November 3, 2022

**RE: Curia Building Addition
34401 Alexander Blvd. NE Albuquerque, NM 87107
Grading and Drainage Plan (F16D003B1)
Engineers Stamp Date 10/25/2022**

Re: Curia Building Addition
4401 Alexander Blvd NE Albuquerque, NM 87107
Grading and Drainage Plan (F16D003B1)
Letter of Response

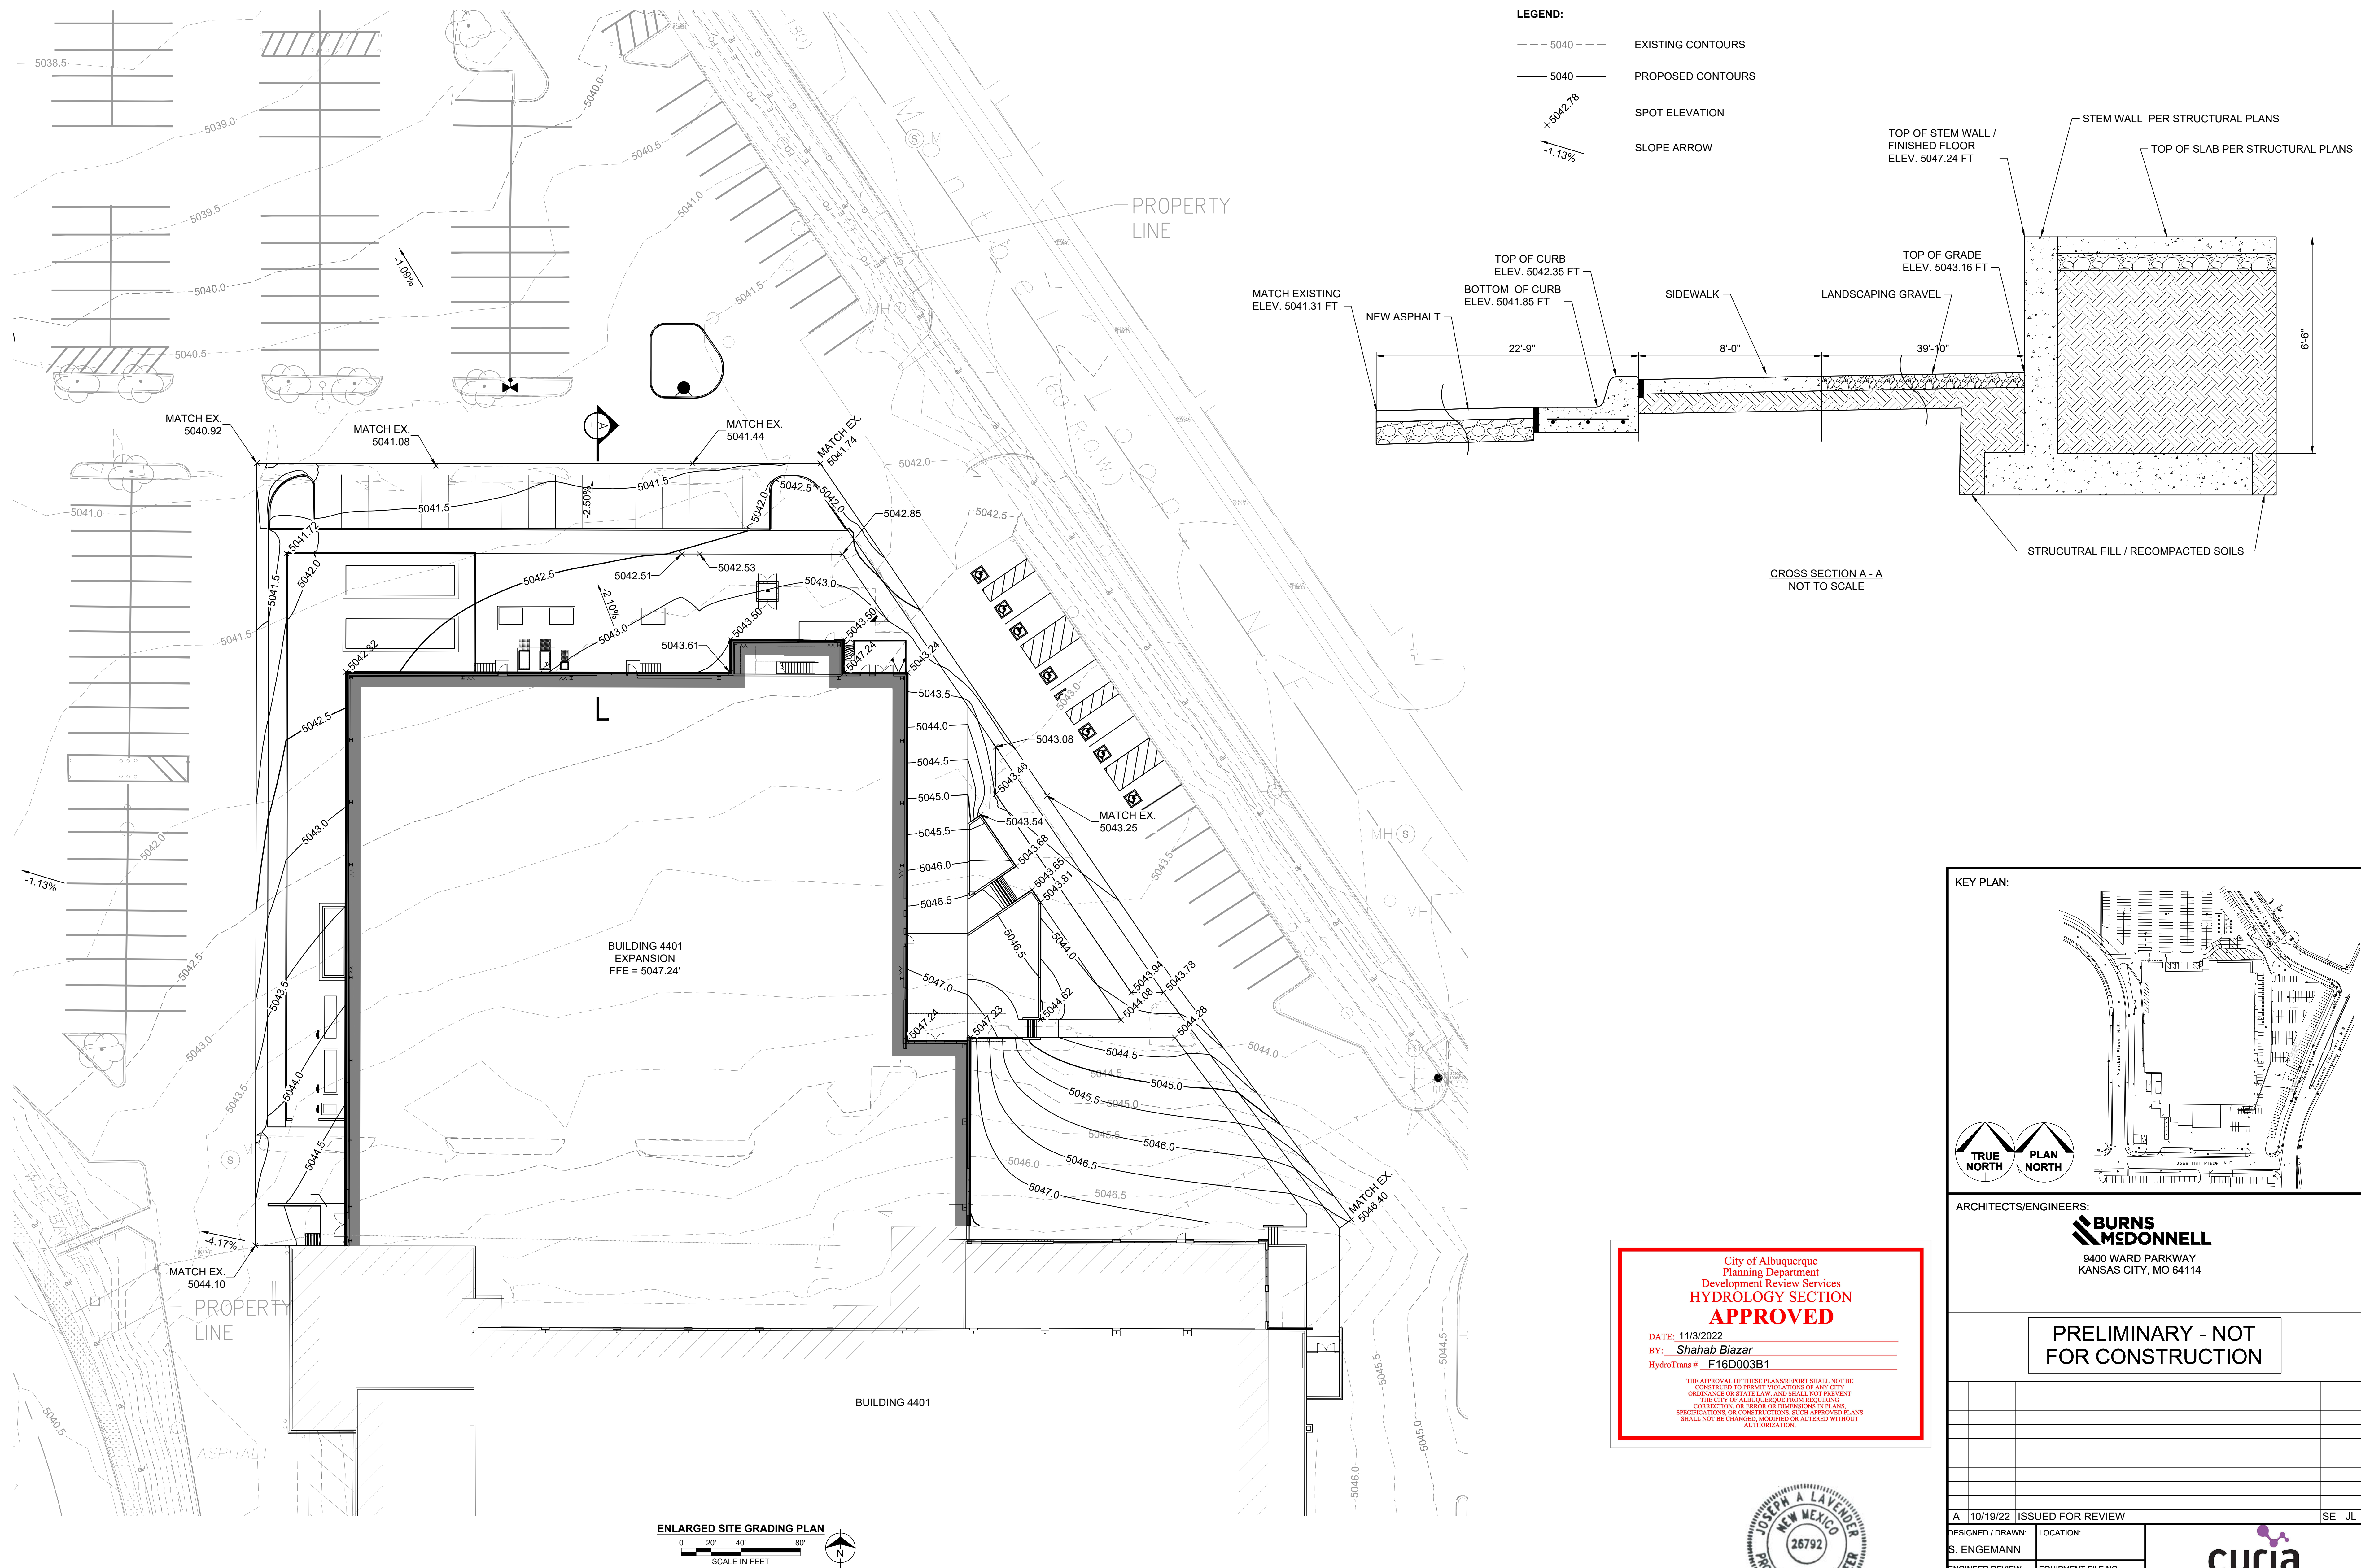
- 4) Provide detail elevation and finished contours around the building and beyond to show how it will tie to the existing grades. To the north the Finished Floor elevation is nearly 6' about the exiting grade. Are there going to be stem walls. Provide cross-sections.
Finish grade and cross section are included on drawing CG102 Enlarged Grading & Drainage Plan.

- 5) First Flush Volume requirement calculations must be provided. How will the first flush volume requirement be handled?
First Flush Volume calculations are included in CG101 Overall Grading & Drainage Plan. The existing / proposed detention pond retains the First Flush within
